**July 16, 2014
DRB Comments**

PROJECT # 1009506

APPLICATION # 14-70238

RE: Montecito West, Unit 1

**Plat for  
 Montecito West, Unit 1  
 Being Comprised of  
 Lots 15-21, Volcano Cliffs Subdivision Unit 6  
 Together with a Portion of Vacated Retablo Road NW  
 and Albericoque Place NW Rights-of-Way  
 City of Albuquerque  
 Bernalillo County, New Mexico  
 July 2014**

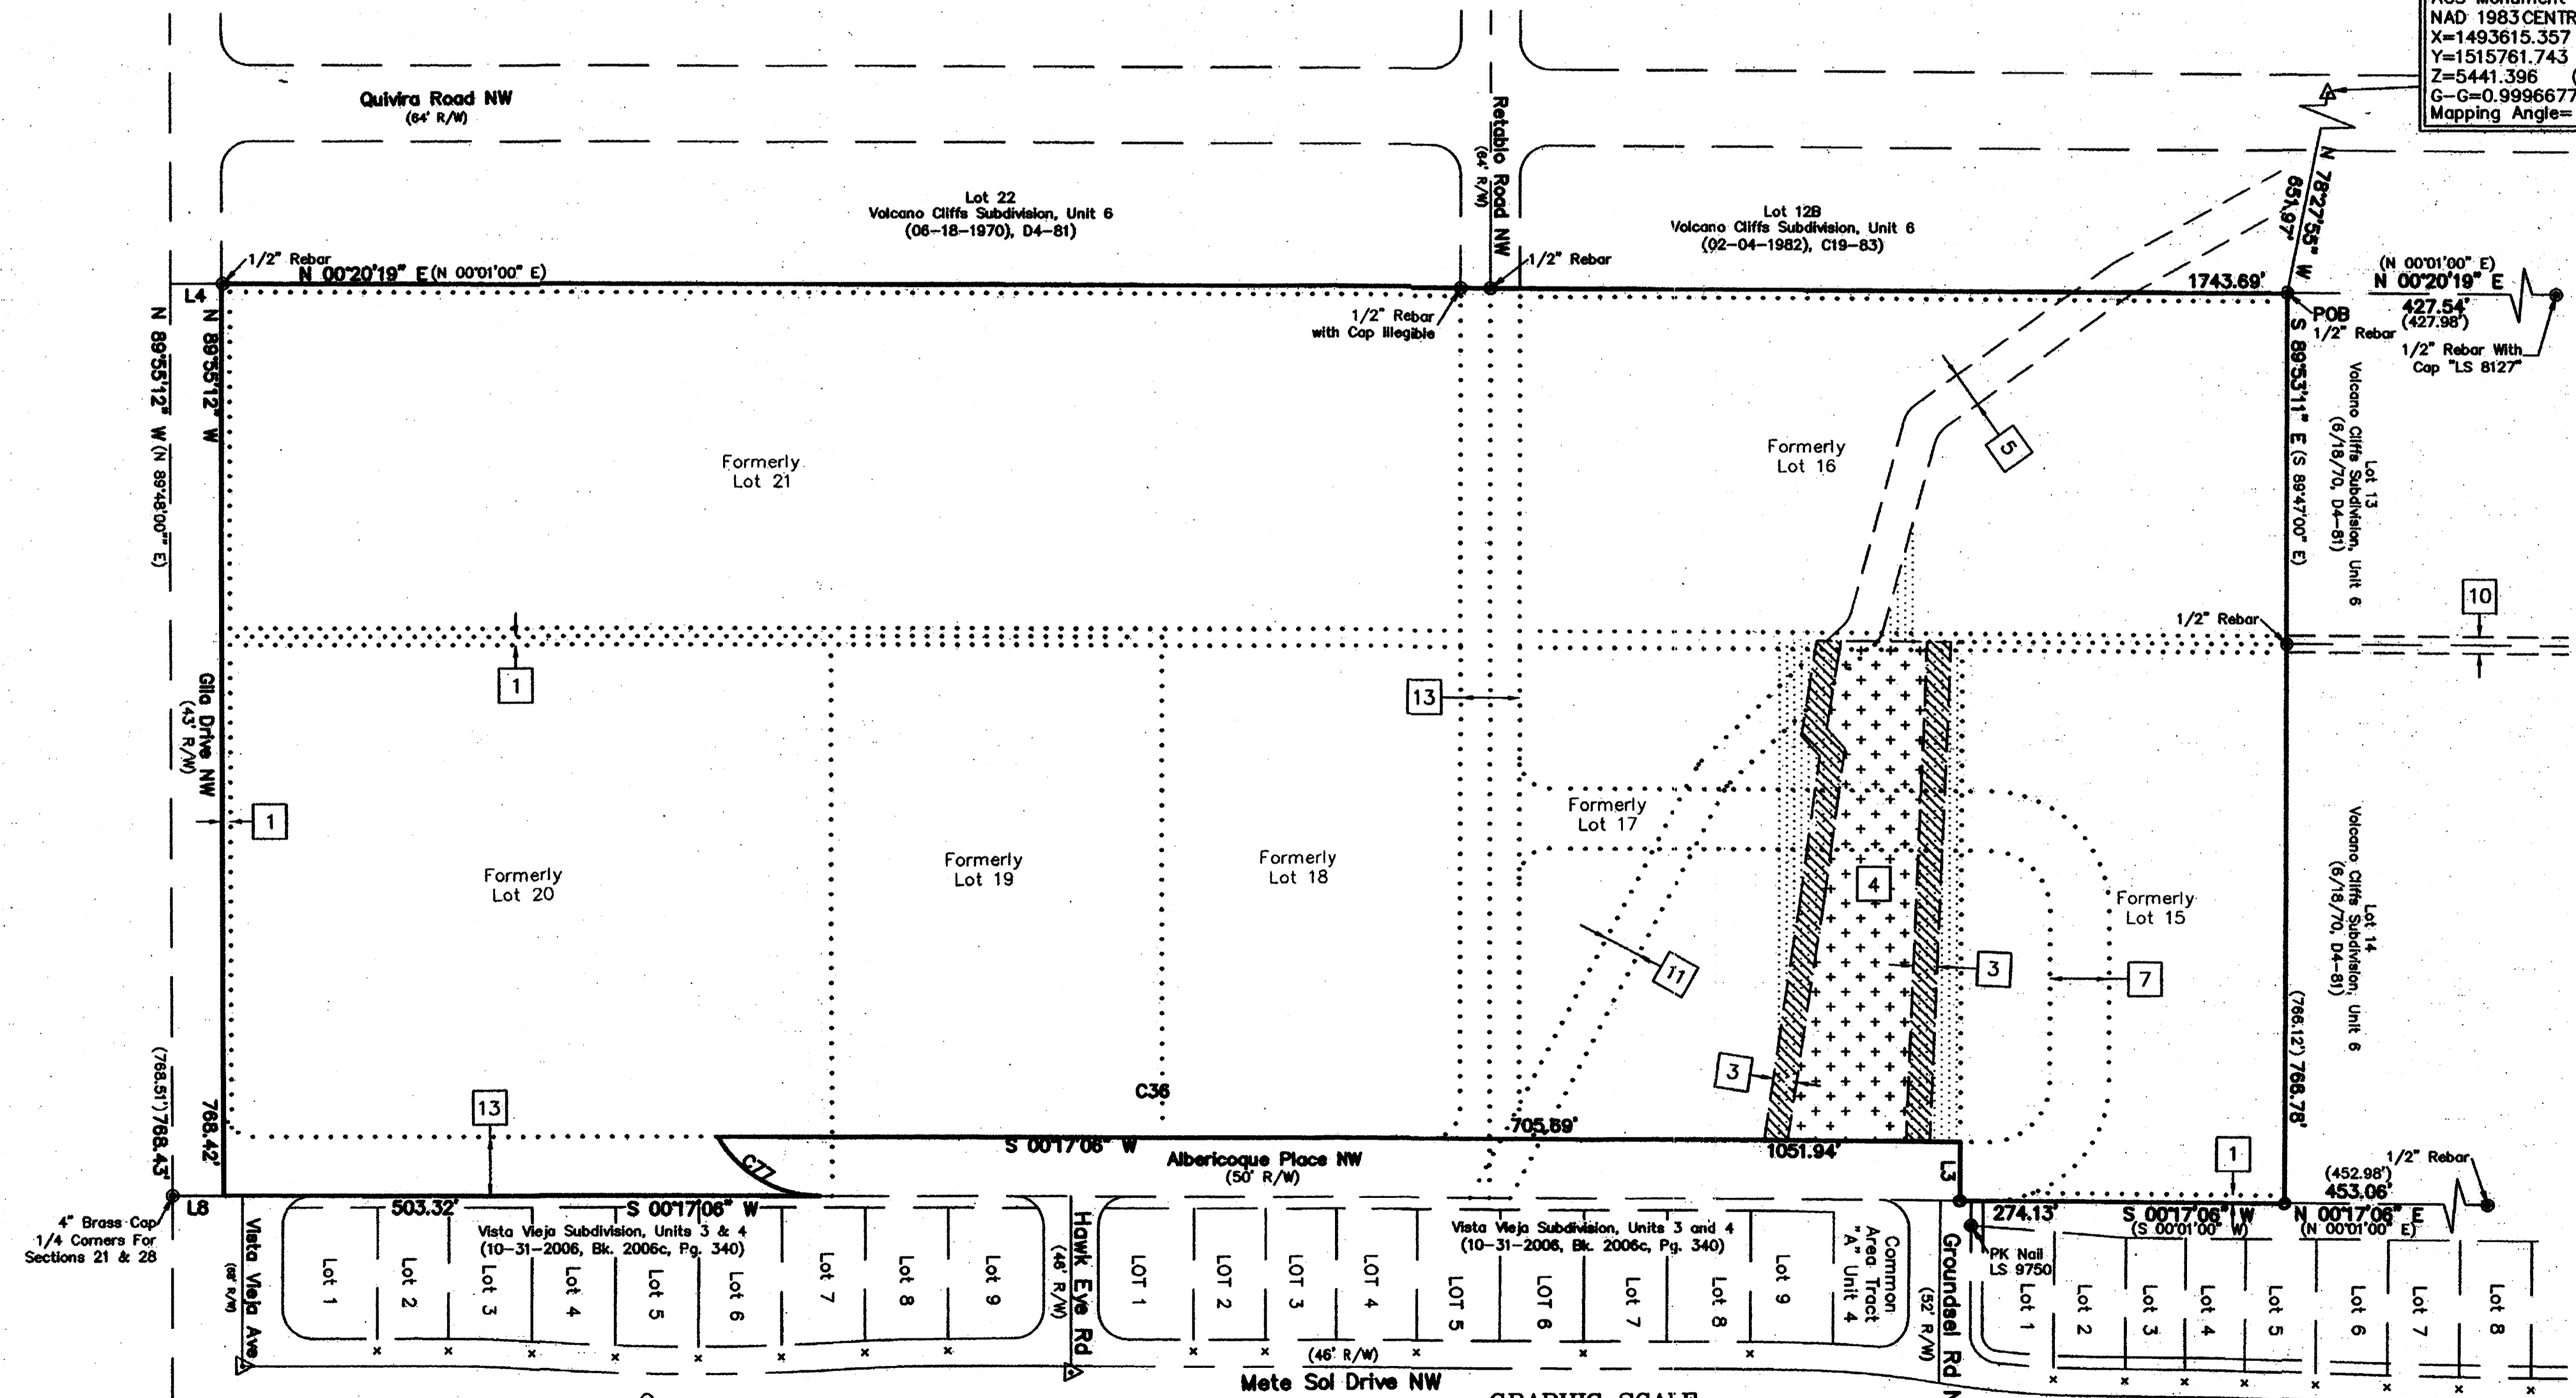
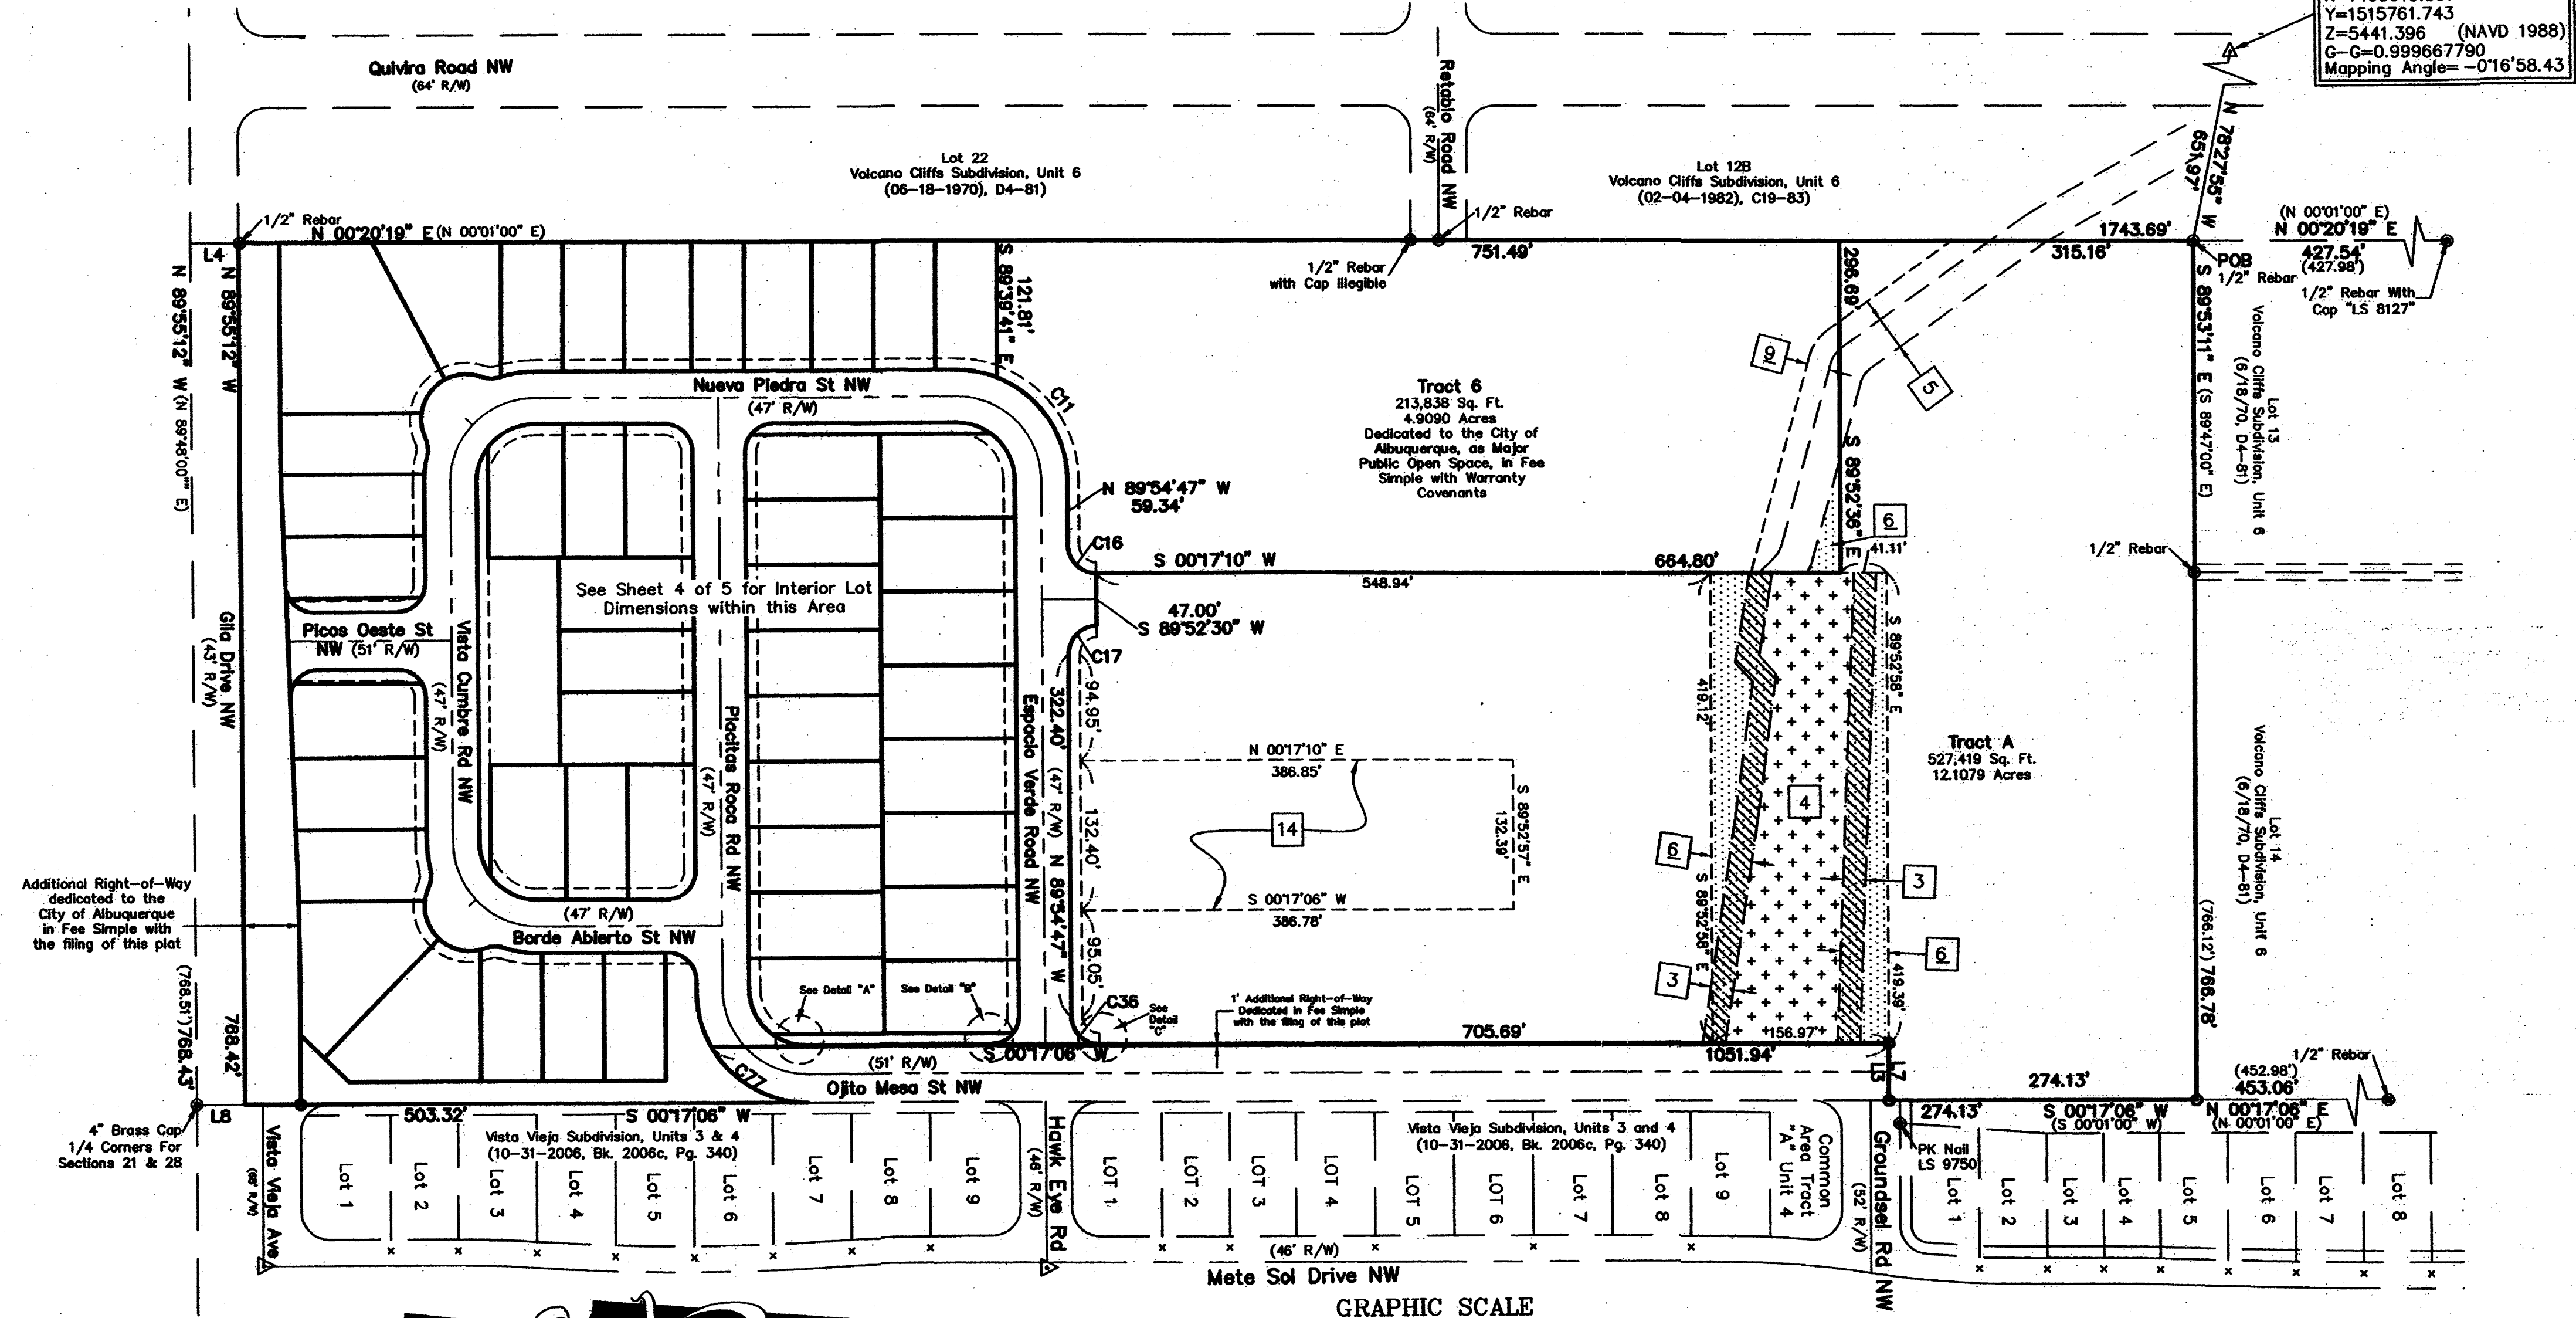
Tracts need to be identified on the plat (use, maintenance, etc.). Tract 6 was to be dedicated as City Open Space, so Open Space should be a signatory to the plat. Real Property needs to sign the plat to verify acquisition of vacated right of way.
